**KIRKLEES METROPOLITAN COUNCIL
INVESTMENT & REGENERATION SERVICE**

DELEGATED DECISION TO DETERMINE PLANNING APPLICATIONS

Reference No: 2020/62/93859/W

Site Address: 56, Stile Common Road, Primrose Hill, Huddersfield,
HD4 6DE

Drawing number
01.

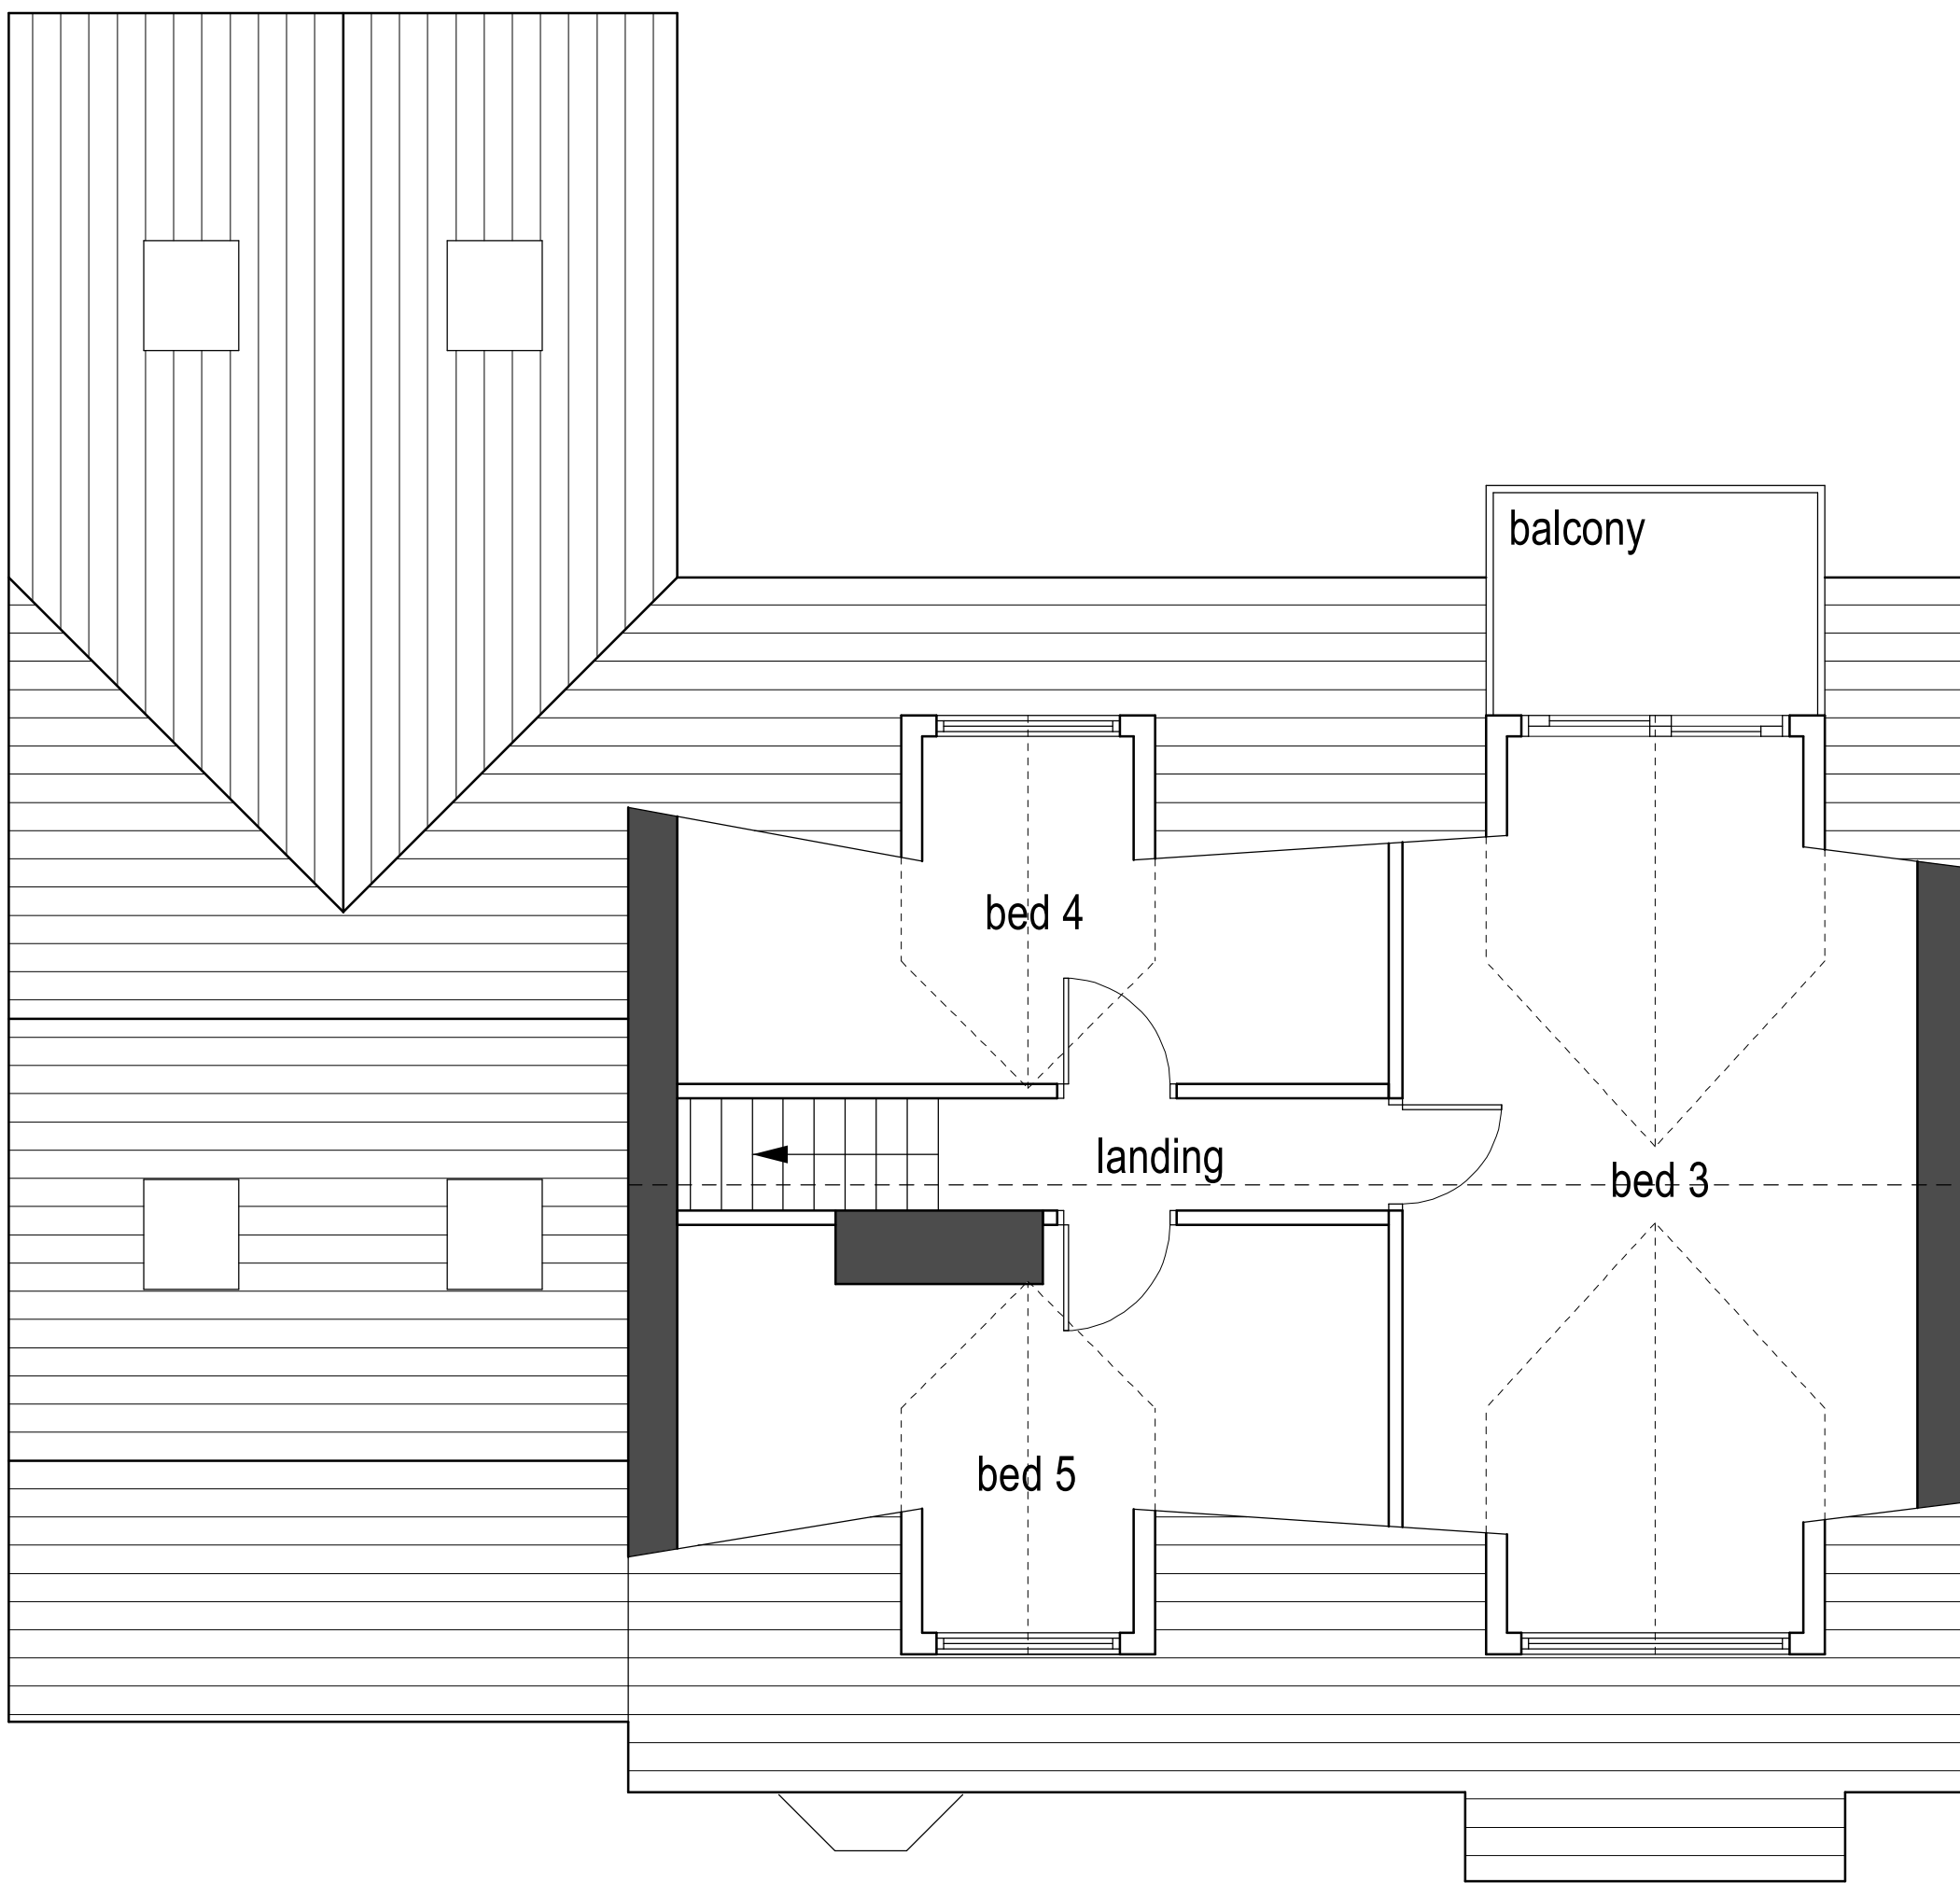
No details have been provided for the construction materials however, officers would like to see the dormers finished in either hanging roof tiles to match of UPVC cladding of a similar colour to the proposed roof tiles. A condition to control this will be attached to the decision notice.

54 Stile Common Road is the neighbouring property to the North West of the application site. Given that this property is a two storey dwelling in which does not appear to benefit from any existing openings within its gable elevation, officers are satisfied that there would be no material overbearing or overshadowing. With regards to overlooking, a small balcony is proposed from the rear dormer, however, this would be retained at a projection of no more than 1.5m and therefore would not be used as the main outdoor amenity space for the host property. Nonetheless, in order to ensure that these neighbours' amenity are protected, a condition will be attached to the decision notice to ensure that the balustrade to the North West (side) is fitted with obscure glazing.

8. Before the first floor balcony is first brought into use, the balustrade along the North Western boundary shall be fitted with obscure glazing. The privacy screen shall thereafter be retained.

9. The front and rear dormers hereby approved shall be constructed from hanging tiles to match the materials used on the host property or from UPVC in a colour to match the proposed roof tiles.

Drawing number
02 A.

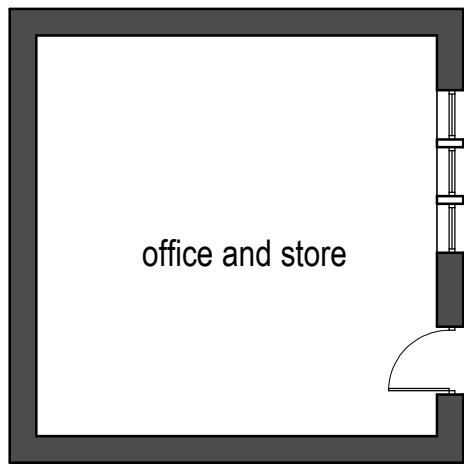
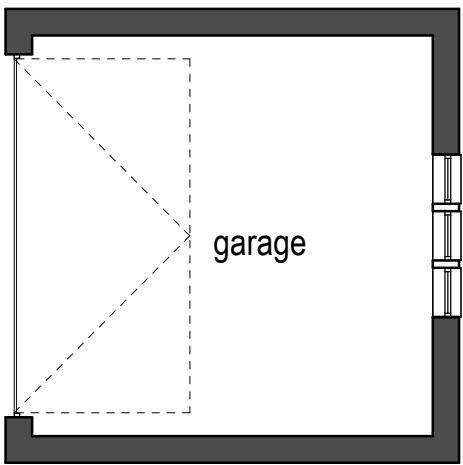
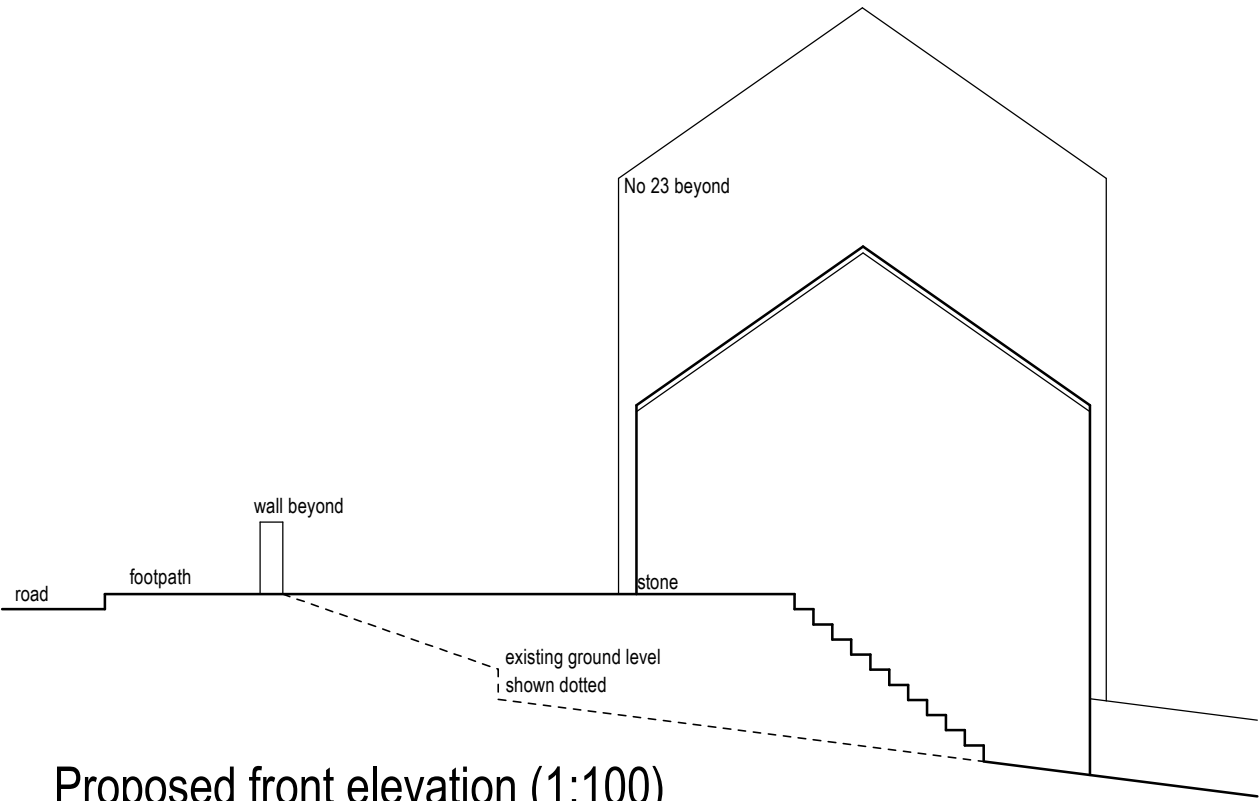
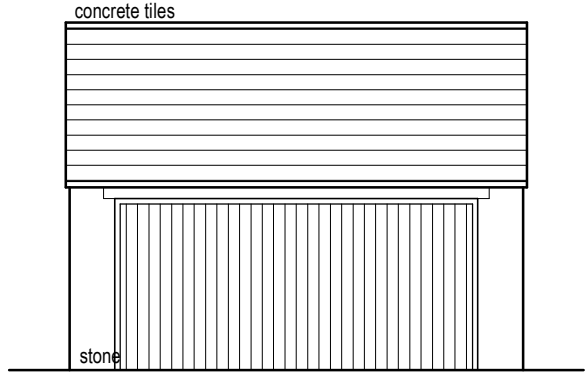
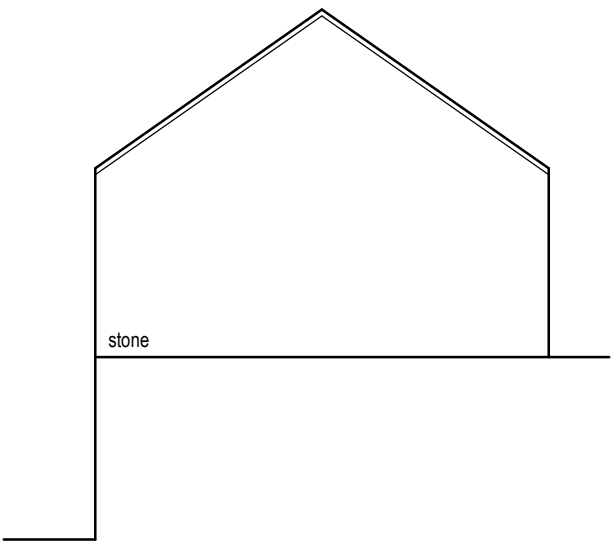
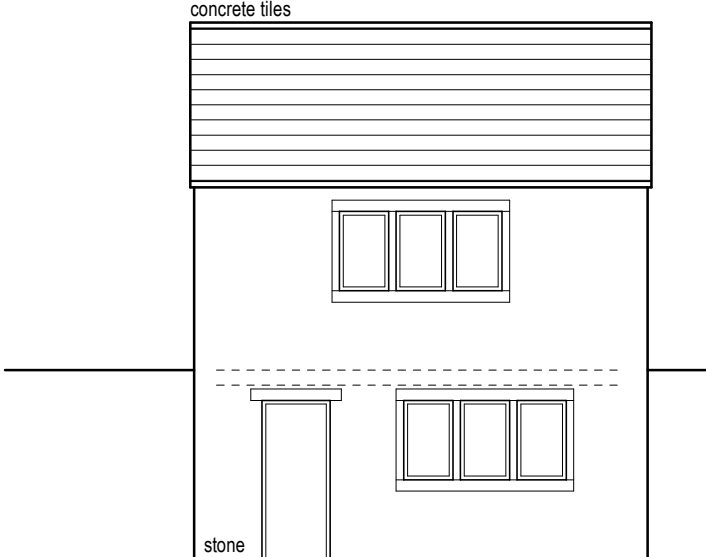
Officers have entered into discussions with the agent regarding the size and scale of the proposed garage. In this instance, amended plans have been sought to reduce the overall height and to create an under build for the office/store. The amended plan was received on the 3rd February 2021.

Amendments have been sought to reduce the size and scale of the detached garage. Along with this, the applicant has also reconfigured the design of the building to incorporate an under build, due to the proposed changes in levels. This will allow the outbuilding to appear more subservient to the host property, whilst reducing its overall size, scale and prominence.

Proposed site plan (1:200)

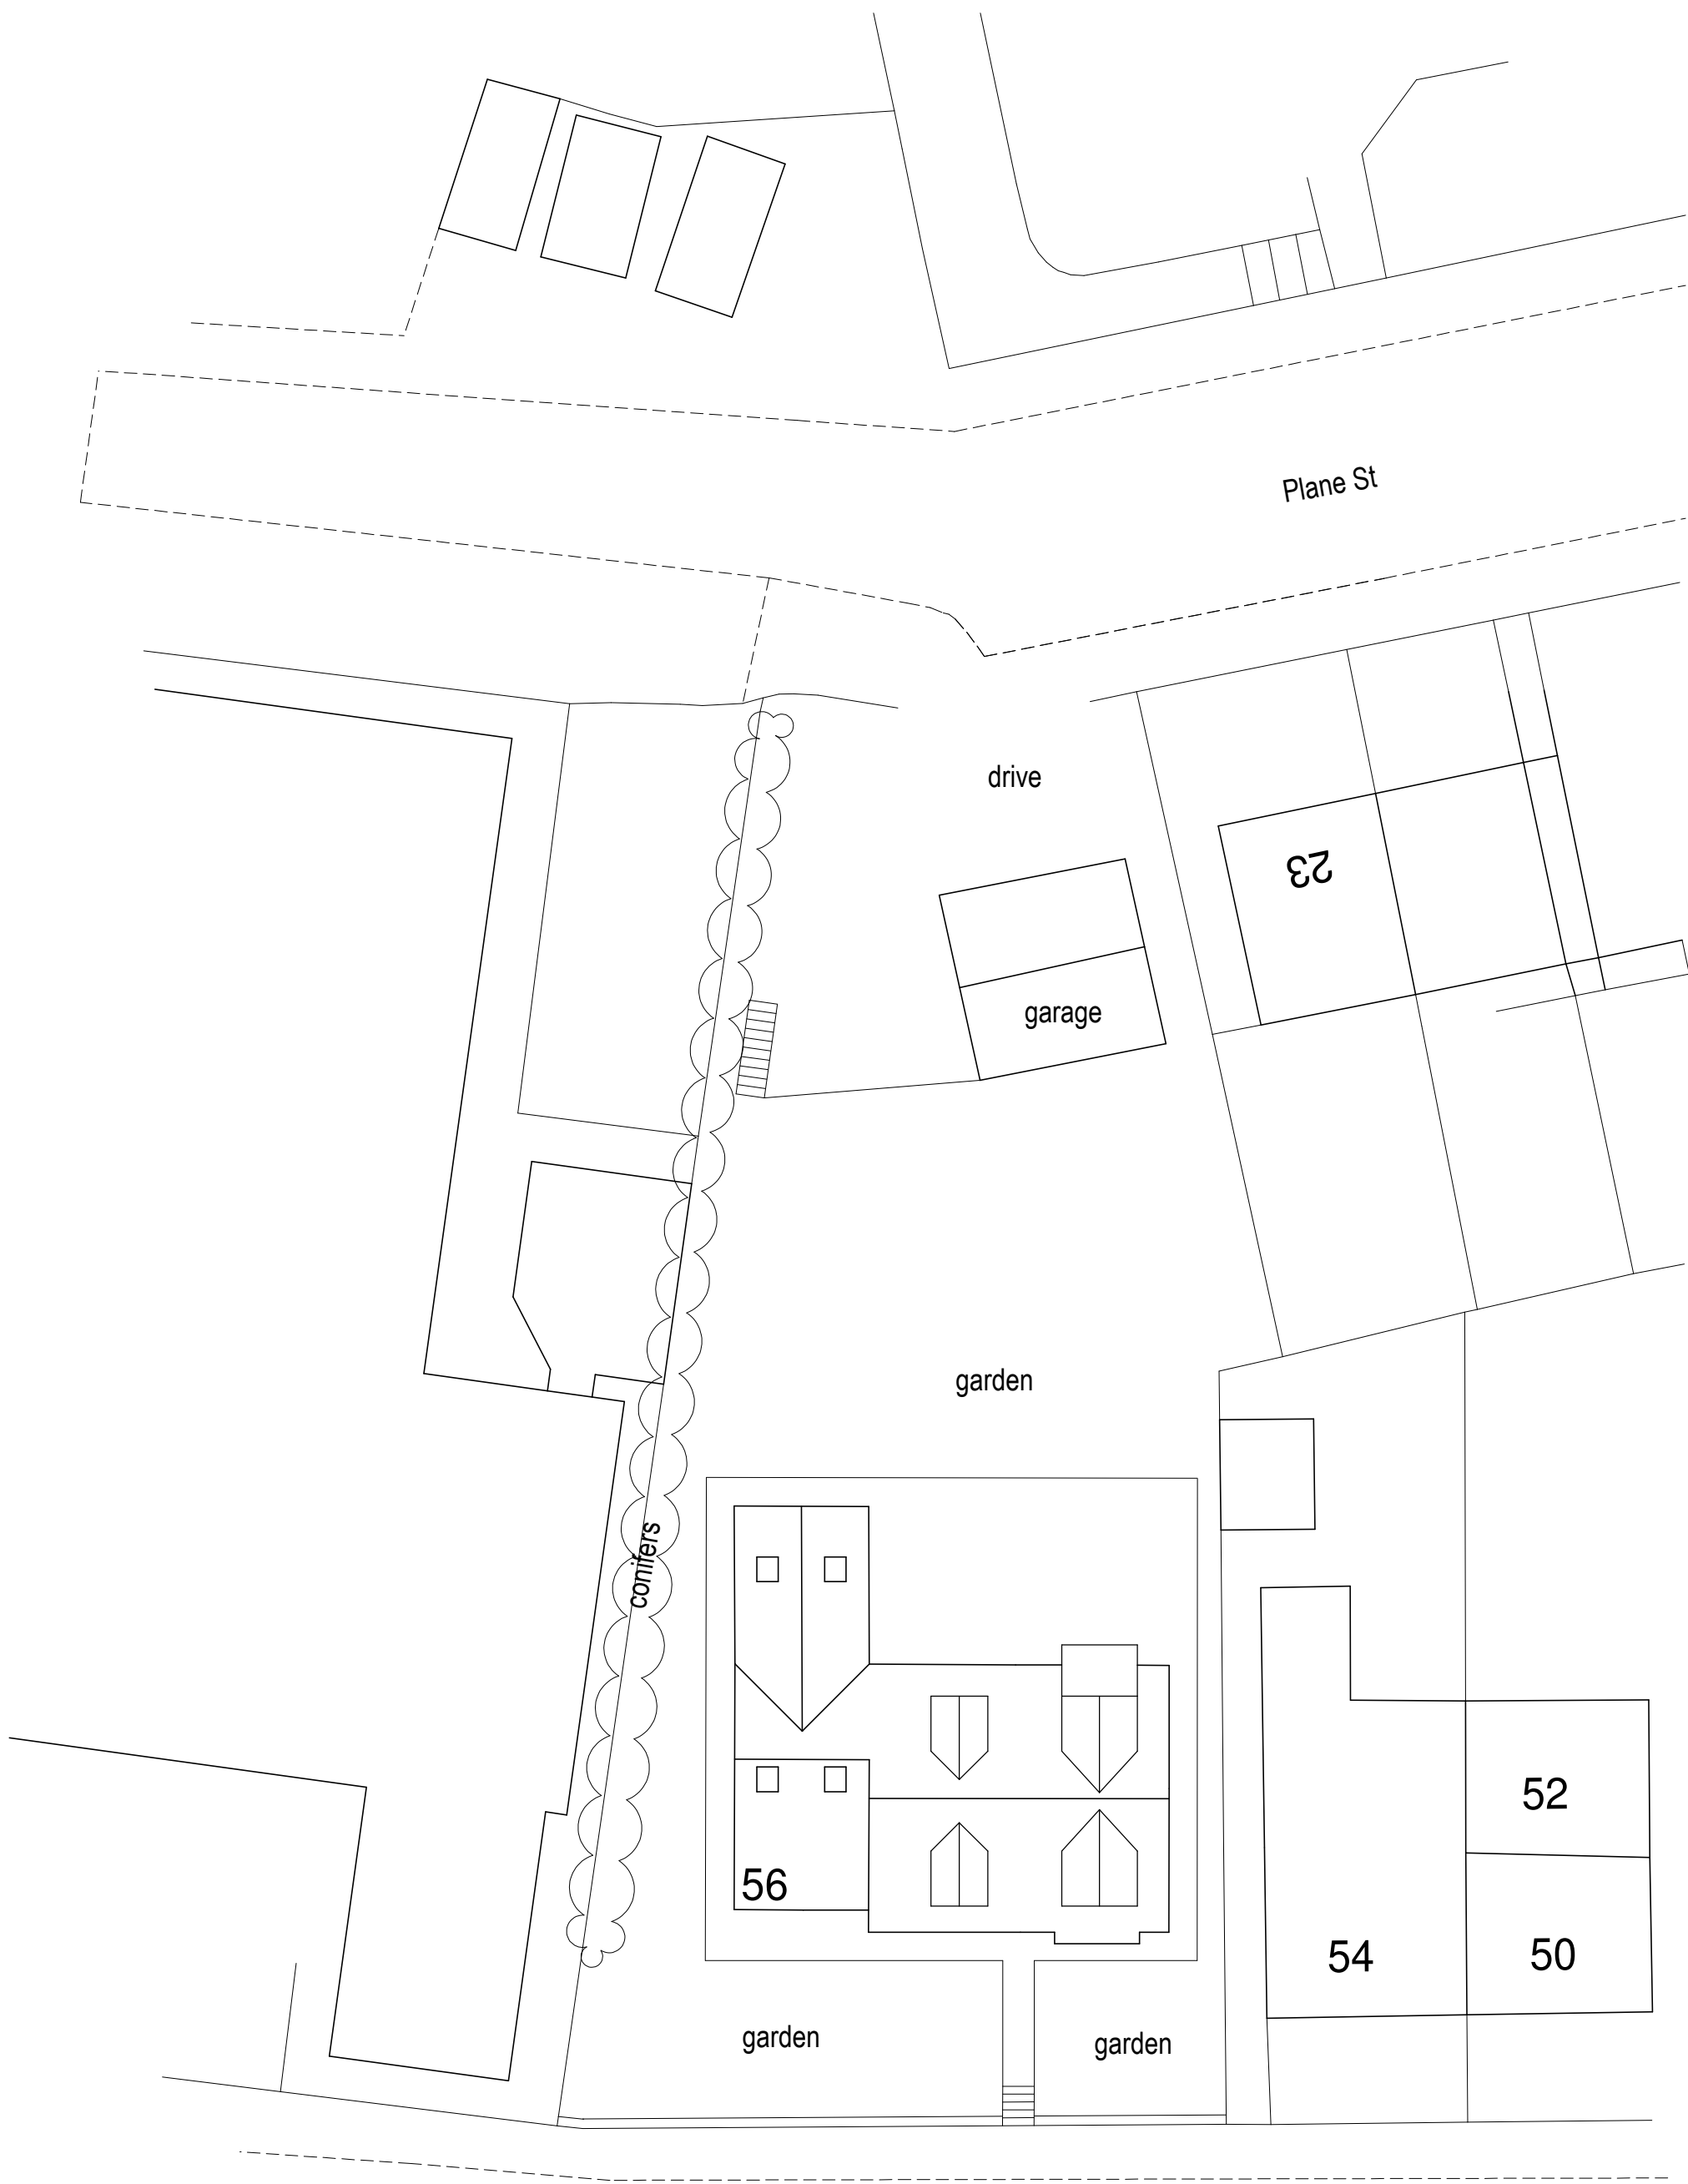
The submitted plans also show a wall to be installed to the rear boundary at a height of 1m. This will provide acceptable visibility splays and therefore no concern has been raised.

6. The extensions and outbuilding hereby approved shall not be brought into use until the extended driveway as indicated on the approved site plan (dwg no. 02 Rev A) has been laid out with a hardened and drained surface in accordance with the Communities and Local Government; and Environment Agency's 'Guidance on the permeable surfacing of front gardens (parking areas)' published 13th May 2009 (ISBN 9781409804864) as amended or any successor guidance; Notwithstanding the provisions of the Town and Country Planning (General Permitted Development) (England) Order 2015 as amended (or any Order revoking or re-enacting that Order) this shall be so retained, free of obstructions and available for parking.
